Recommendation Report for Planning Permission

REF NO: BR/31/20/PL

LOCATION: 77 Aldwick Road
Bognor Regis
PO21 2NW

PROPOSAL: Part change of use of ground floor & formation of a first floor rear extension to create 2 No. self-contained studio flats with associated refuse/recycling & cycle store (re-submission following BR/233/19/PL)

Drawing
EXISTING & PROPOSED
ELEVATIONS

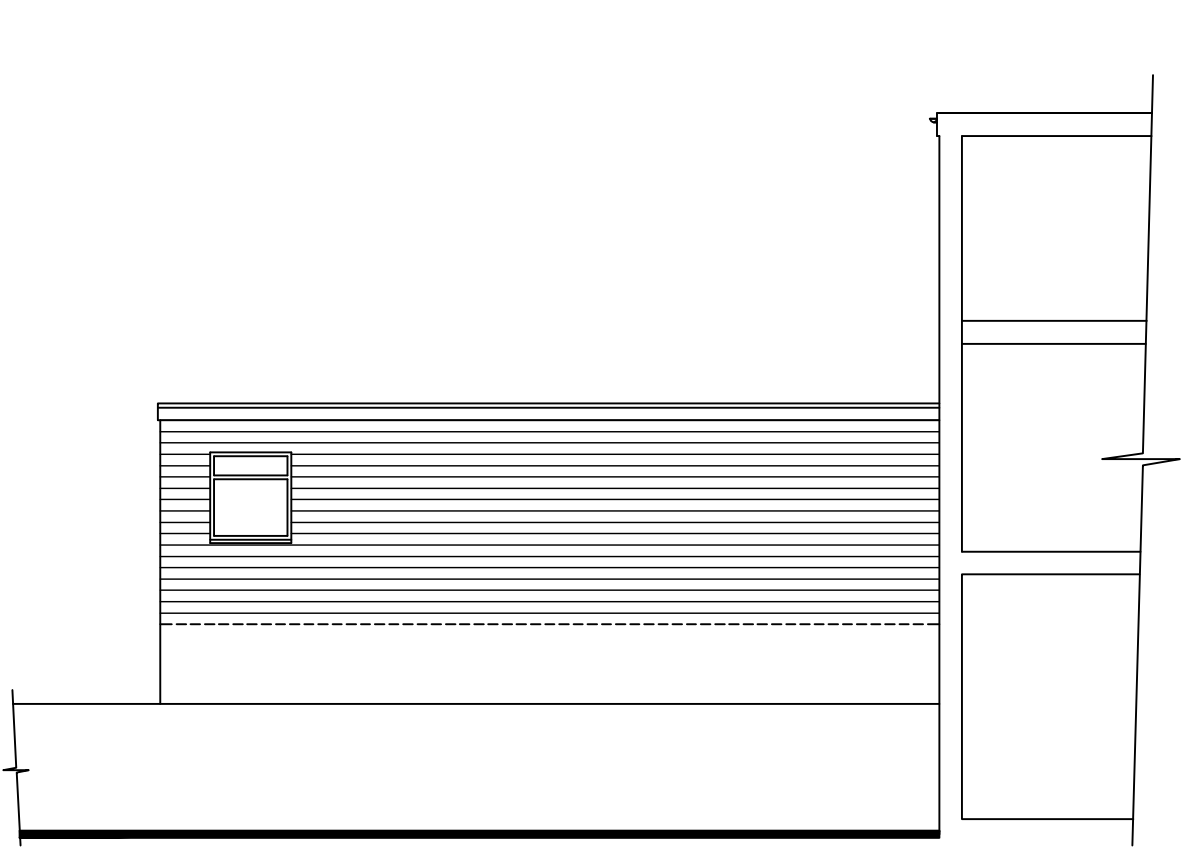
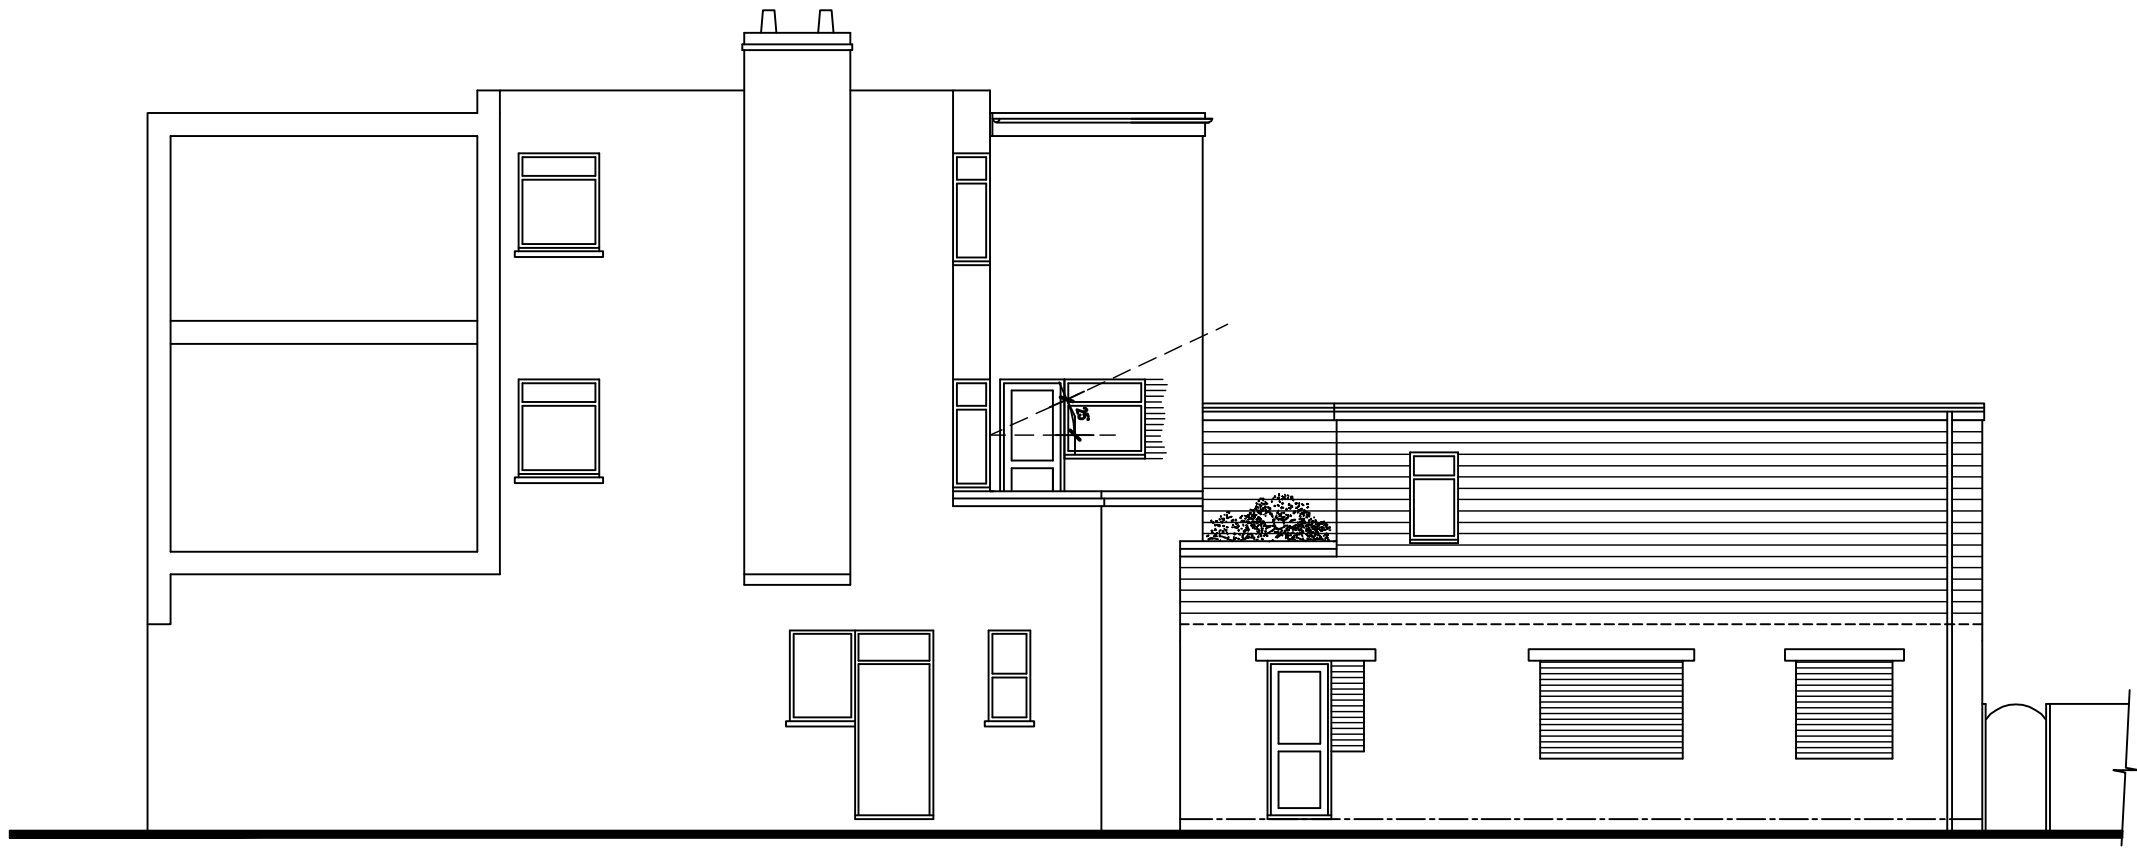
The first floor flat roof rear extension would be approximately 2.7m high and would be attached to the

host building regardless of its fenestration. A similar coloured materials palette and window design that accord with the main building are proposed. The extension would be subservient to the host building and being to the rear of the property also means that it will not be visible in the street-scene. Therefore it is not considered to compromise the spatial character of the area.

- 2 The new first floor studio apartment's window on the southern elevation of the proposed extension will look out towards the rear private amenity spaces of Nos.10 and 14/16 Stocker Road at a distance of around 8.8m. This will result in a loss of privacy to the adjacent amenity spaces of nos.10 and 14/16 Stocker Close and the proposal is therefore contrary to policies D DM1, D DM4 and QE SP1 of the Arun Local Plan and National Planning Policy Framework.
